State of Washington  
DEPARTMENT OF FISH AND WILDLIFE

December 22, 2025

SUBJECT: WDFW COMMENTS ON RU-25-00003 Sage

SAGE CABIN STREAM BUFFER AVERAGING EXHIBIT

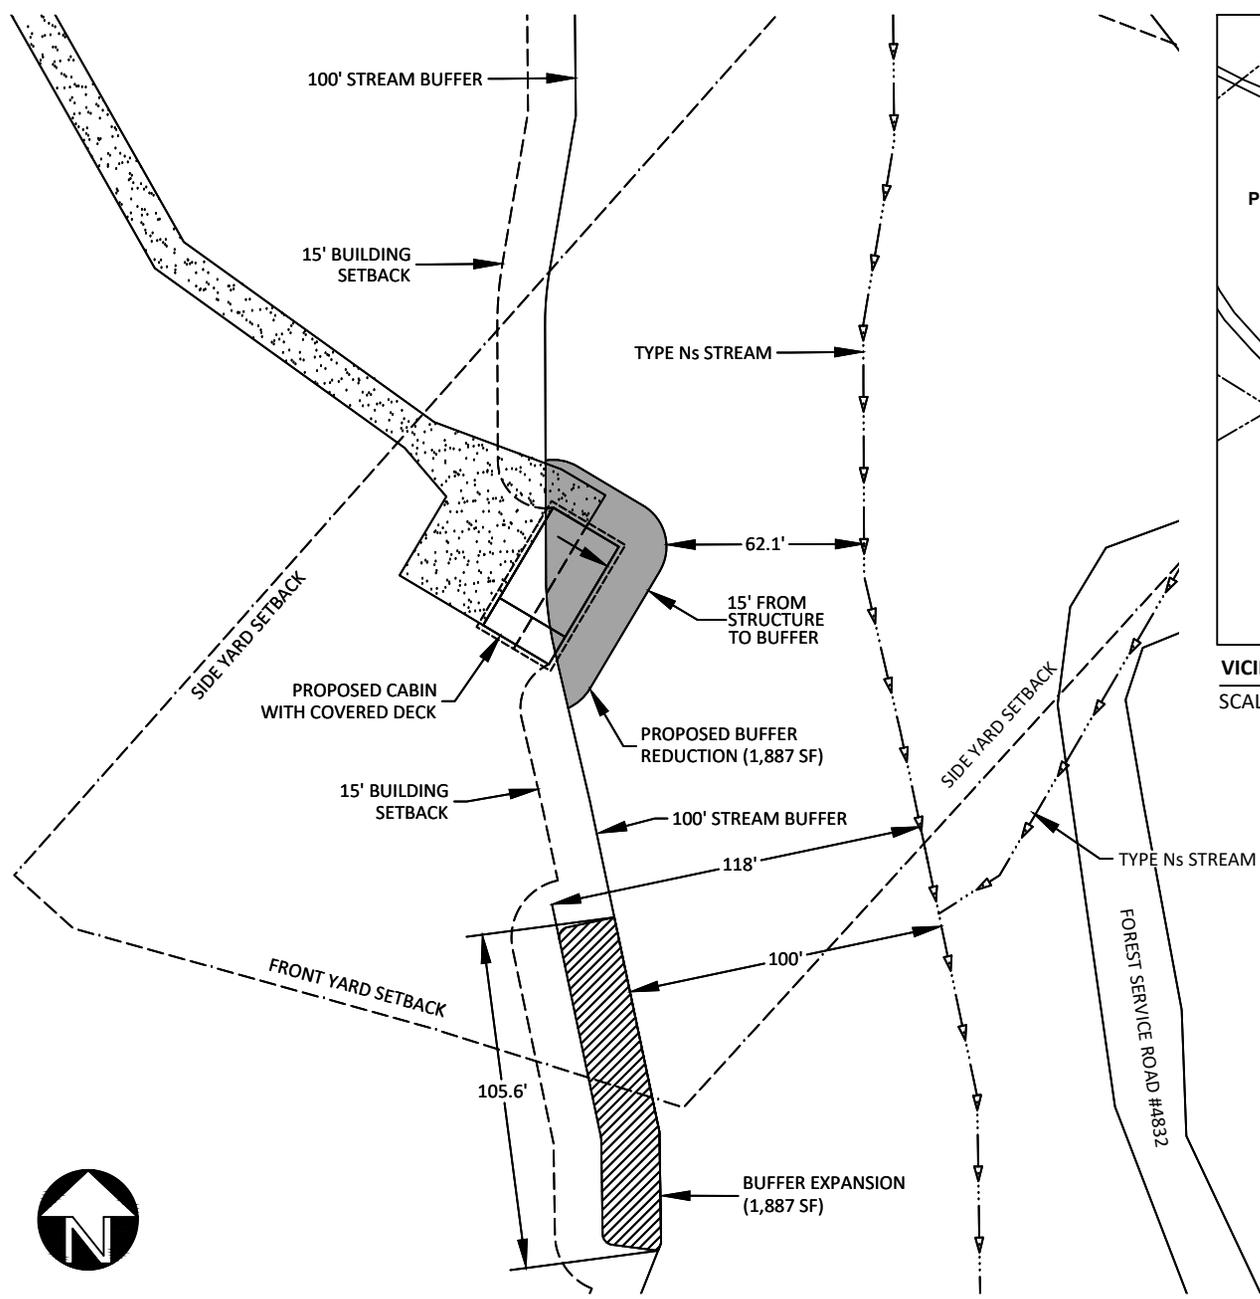
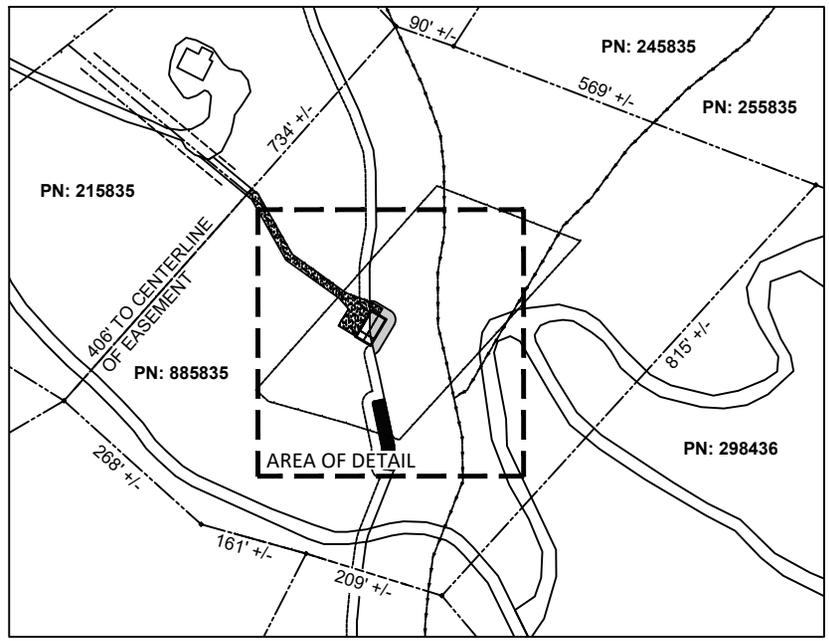
The proposed cabin location is within the Riparian Management Zone (RMZ, CAO 17A.04.030) of Townsend Creek. RMZs shall be maintained in a predominantly well-vegetated and undisturbed condition to ensure that they perform their intended function and value of protecting the FWHCAs. The RMZ width shall be either the site-specific Site Potential Tree Height (SPTH) or 100 feet, whichever is greater, consistent with Best Available Science for pollution removal and Volume 2 of WDFW's Riparian Ecosystem Management Recommendation (CAO 17A.04.030(2)). Using the [SPTH mapping tool](#), the RMZ buffer at this location is 109 feet.

To ensure no net loss of function and value of the RMZ, we recommend avoiding and minimizing impacts to the RMZ as much as possible by siting the cabin and any associated infrastructure as far away from the stream as feasibly possible. Where impacts cannot be avoided, mitigation will be needed to offset the impacts to Townsend Creek's riparian buffer.

The critical areas report states "To compensate for the 1,887sf of permanent impact to the buffer from the home and road, an equal amount of buffer (1,887sf) will be added to the stream buffer as compensation." We request clarification on what this means. Are stream or riparian enhancements proposed within this area? WDFW believes preservation alone doesn't achieve no net loss. Further, according to the Stream Buffer Averaging Exhibit in the critical areas report, a portion of the proposed buffer expansion is beyond the stream's riparian buffer area, as defined by WDFW's Site Potential Tree Height mapping tool. We don't believe buffer averaging is appropriate in this situation.

We recommend development of a mitigation plan, to be reviewed and approved by WDFW prior to construction, as a condition of the reasonable use determination. The mitigation plan should quantify the proposed mitigation measures and demonstrate equivalent or greater biological functions of FWHCAs consistent with Kittitas County's Critical Areas Ordinance (CAO 17A.04.070). If developing a planting plan, it should include monitoring to ensure survivability of the planted plants. We recommend at least three years of monitoring with an 80% survivability. If metrics fall below 80%, we recommend that similar plants be planted to replace those that did not survive.
